COUNTY COUNCIL'S RESPONSE TO CONSULTATION ON THE FOLLOWING DEVELOPMENT PROPOSAL

Application No: 21/00690/REM

Proposal: Variation of conditions 1 (plans), 3 (landscaping scheme), 5 (cycle parking), 6 (sustainability and energy statement) of 17/01542/REM - amendments to Units 1 and 3

Location: Oxford Technology Park, Langford Lane, Kidlington

dra.no: 2647 - 102 revision: PL3

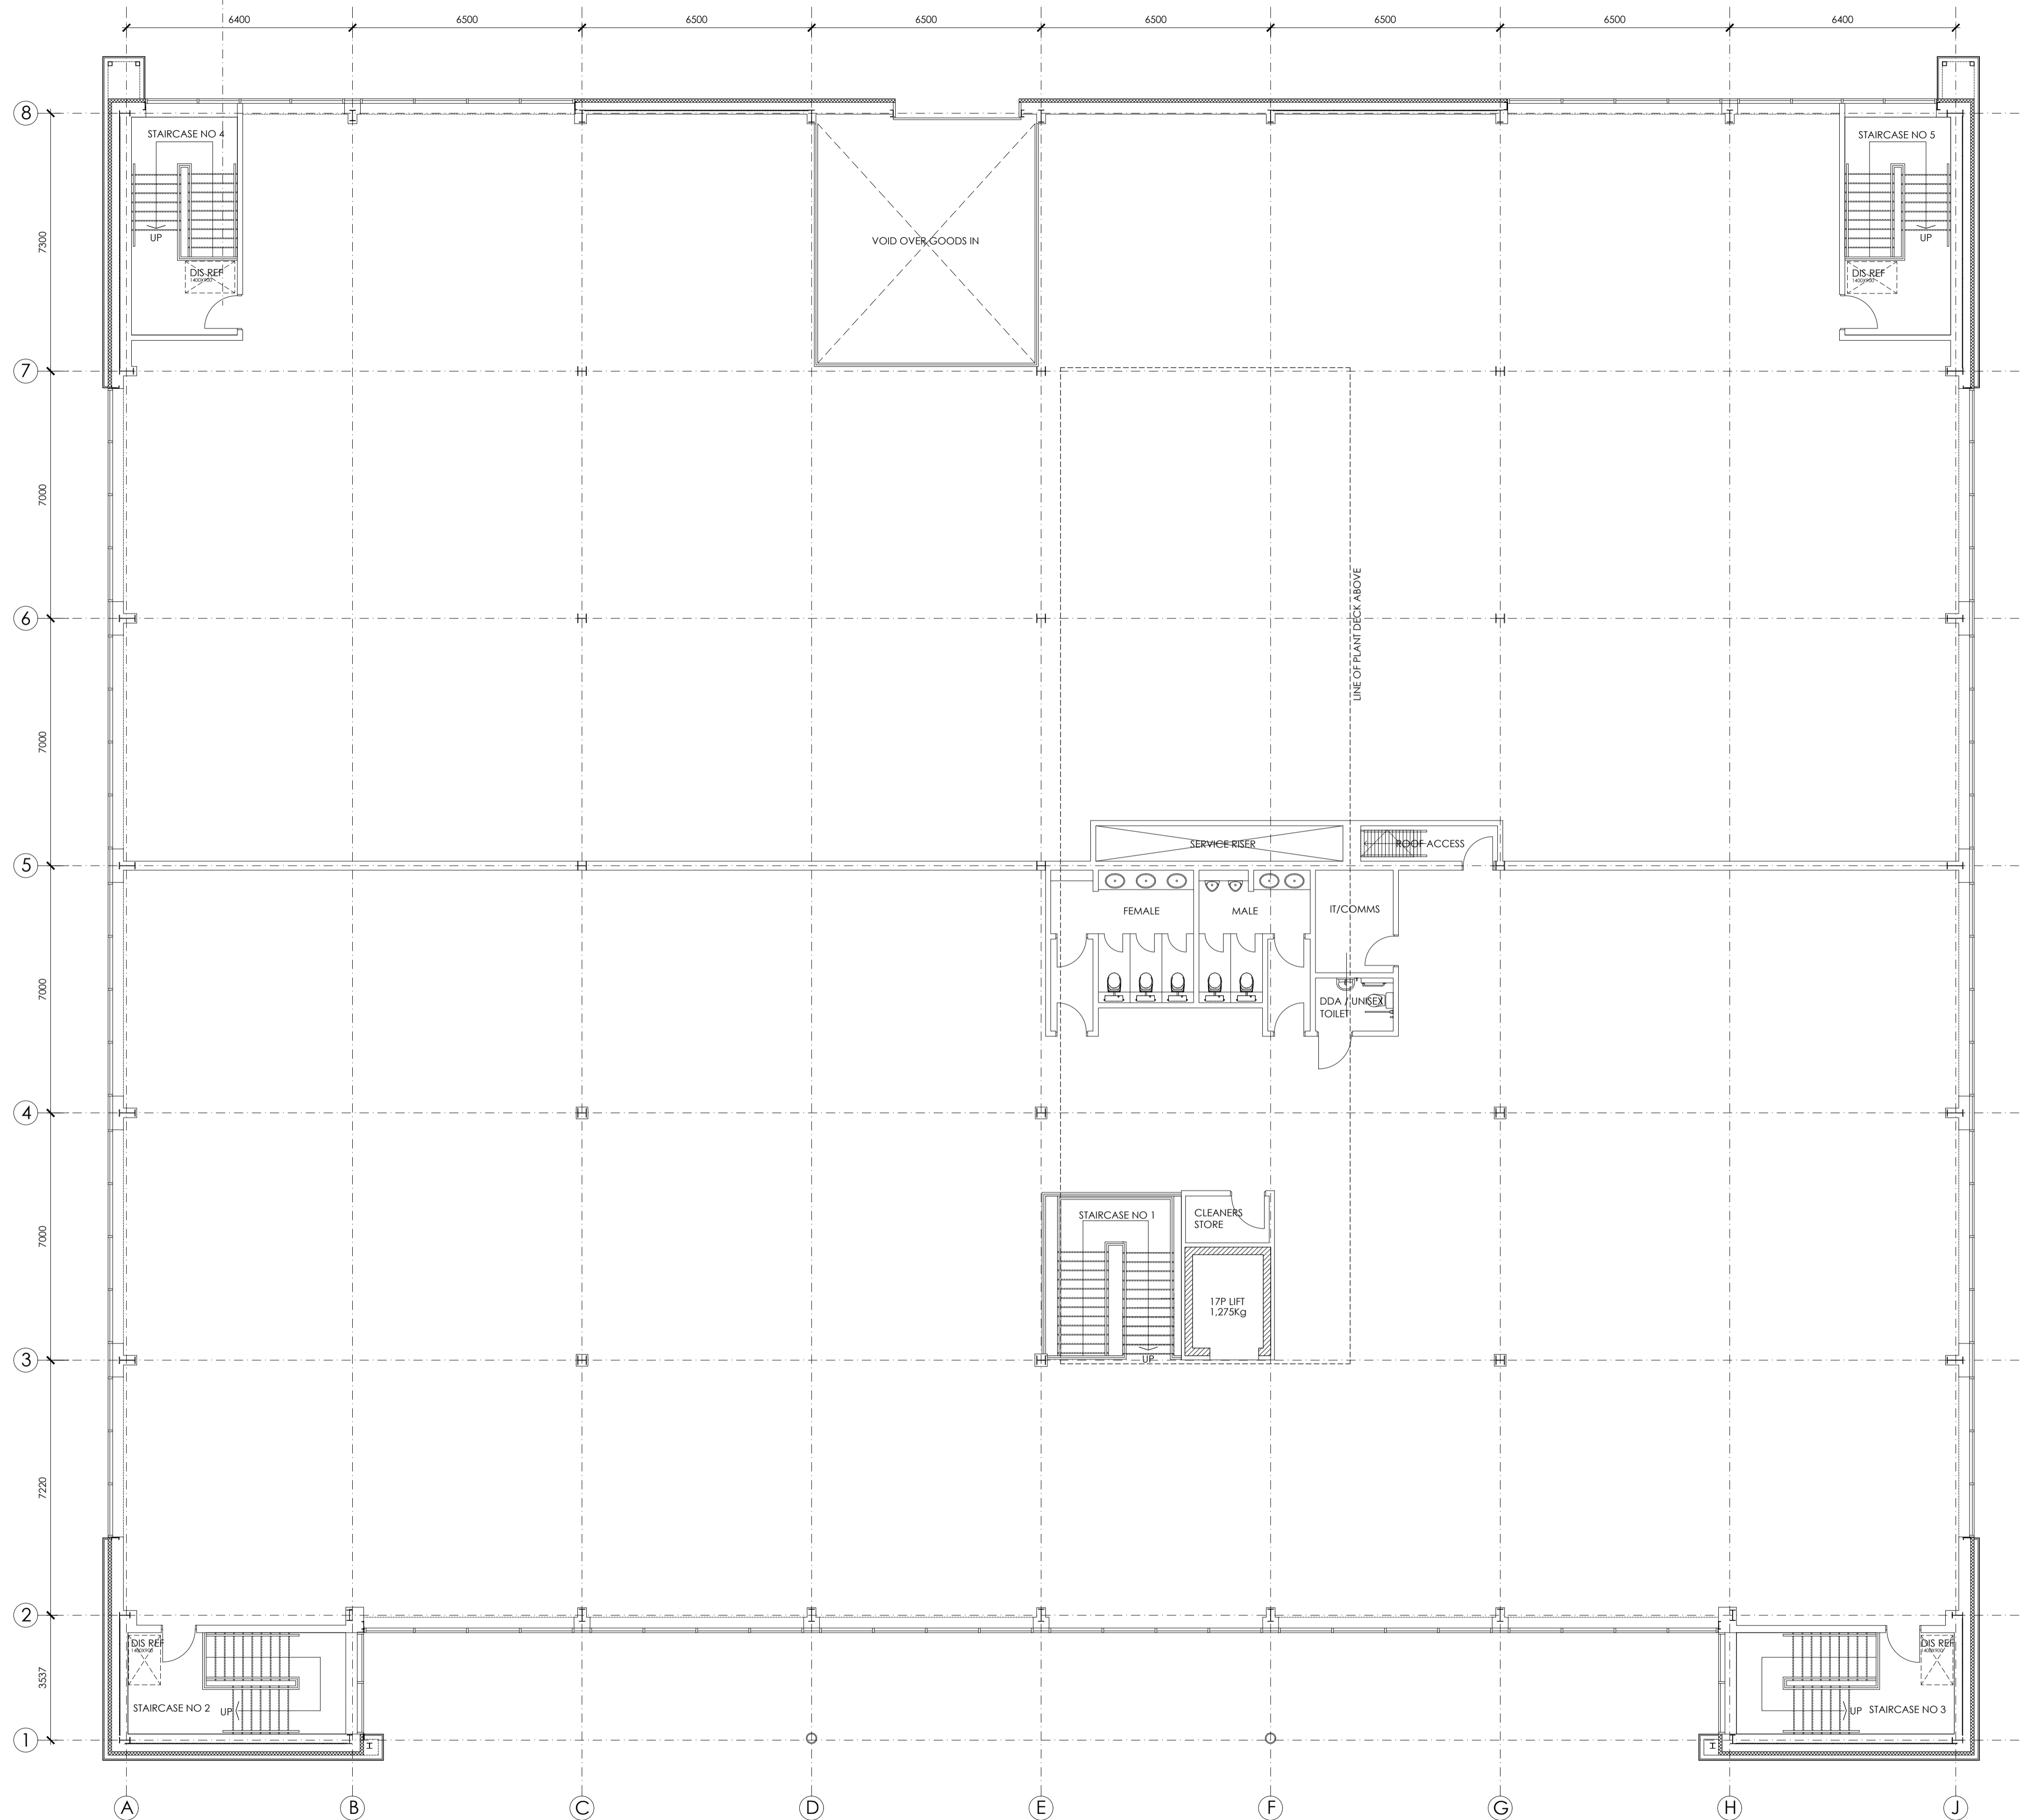
The substantial increase in mezzanine floor area in Unit 3 will result in an overall increase in GIA of 60%. Whilst it is unlikely that the expected number of employees at the site will increase by this extent, I am happy for the number of car parking spaces to increase from that previously approved (46) in proportion to the floor area.
